Our Ref: 2018/91661

**TOWN AND COUNTRY PLANNING ACT 1990, Section 62**  
**TOWN AND COUNTRY PLANNING (APPLICATIONS) REGULATIONS 1988, Regulation 4**  
**TOWN AND COUNTRY PLANNING (DEVELOPMENT MANAGEMENT PROCEDURE) (ENGLAND) ORDER 2015 Article 34**

I refer to your planning application received on 22-May-2018 for Outline permission for residential development and facilitating engineering operations and full planning permission for access and spine road at Land at Walkey Terrace and Brunswick Street, Heckmondwike, application number 2018/91661.

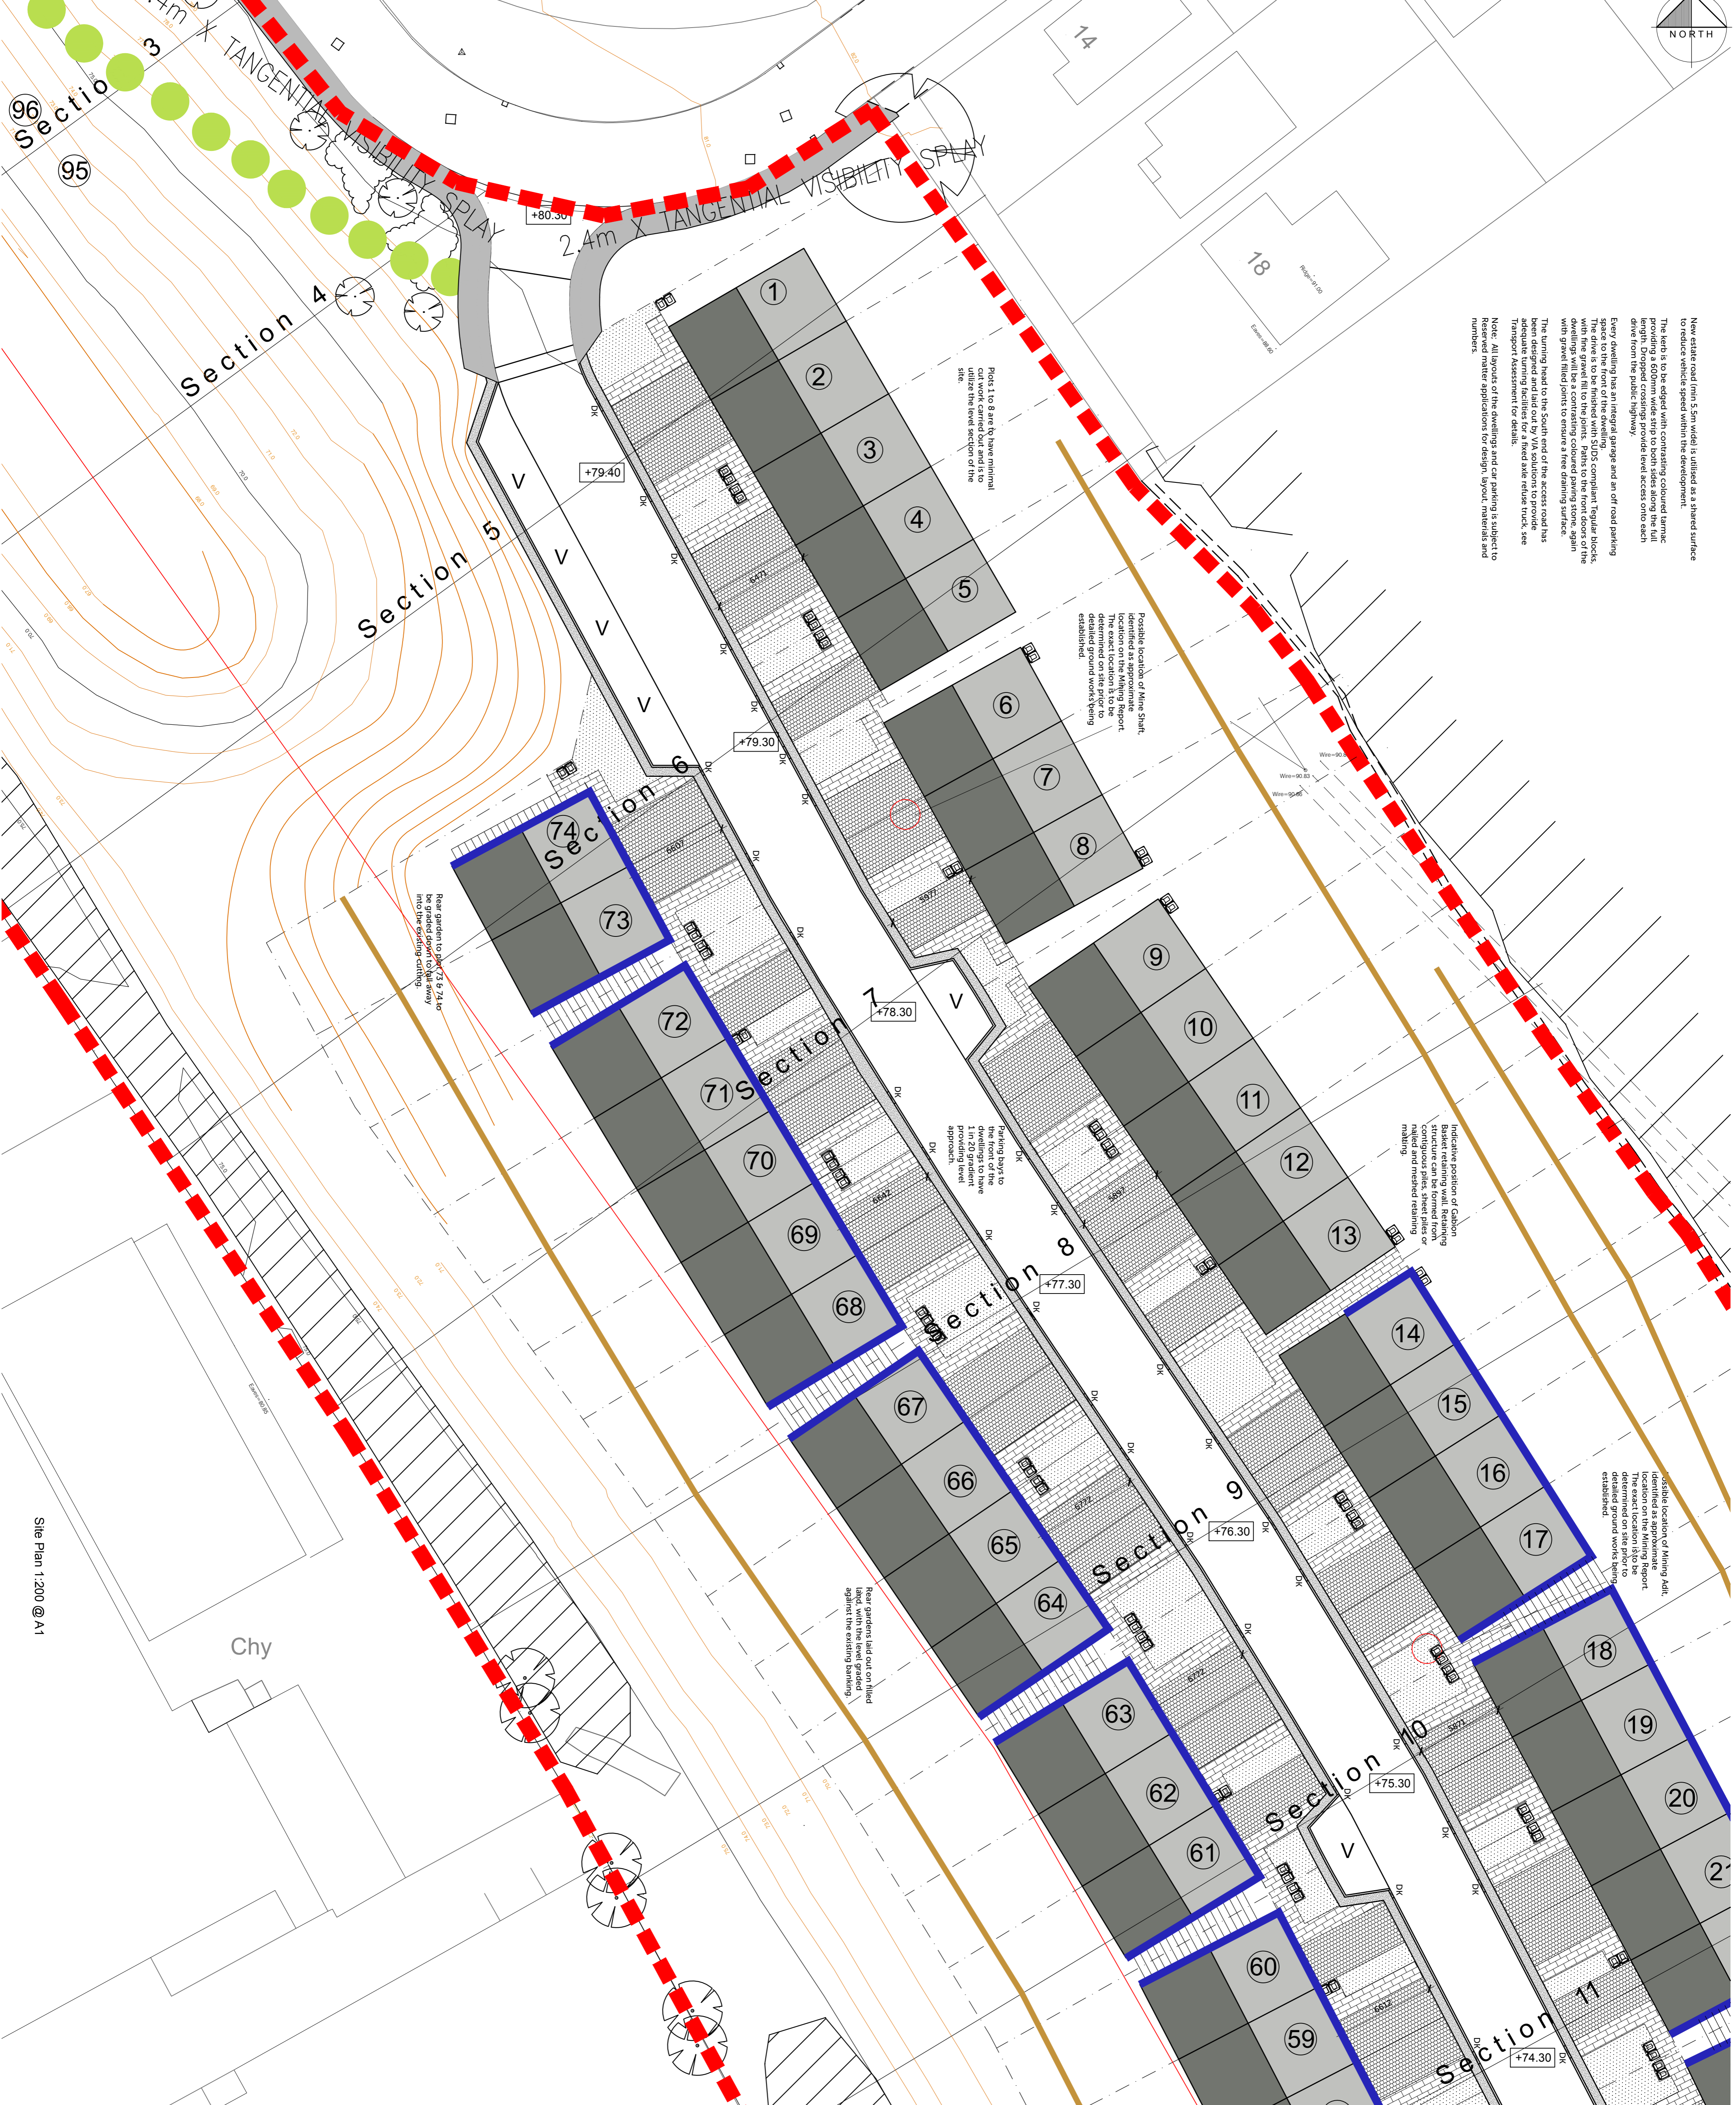
This site is within an area where historic coal extraction has taken place and shafts and adits are known to exist in close proximity. There is also the possibility that unknown workings are present which could be disturbed by excavation works associated with the extensive cut and fill proposals. As this proposal would involve the removal of significant sections of the eastern embankment to provide sufficient fill material, there is therefore the potential for this to result in instability affecting neighbouring land. You will be aware that para 121 of the National Planning Policy Framework requires that local planning authorities should, when making planning decisions, ensure that sites are suitable for proposed uses taking into account, amongst other things, land stability.

- A geotechnical stability assessment which assesses the potential for excavations associated with this development to cause instability in adjacent land and appropriate remediation strategies.
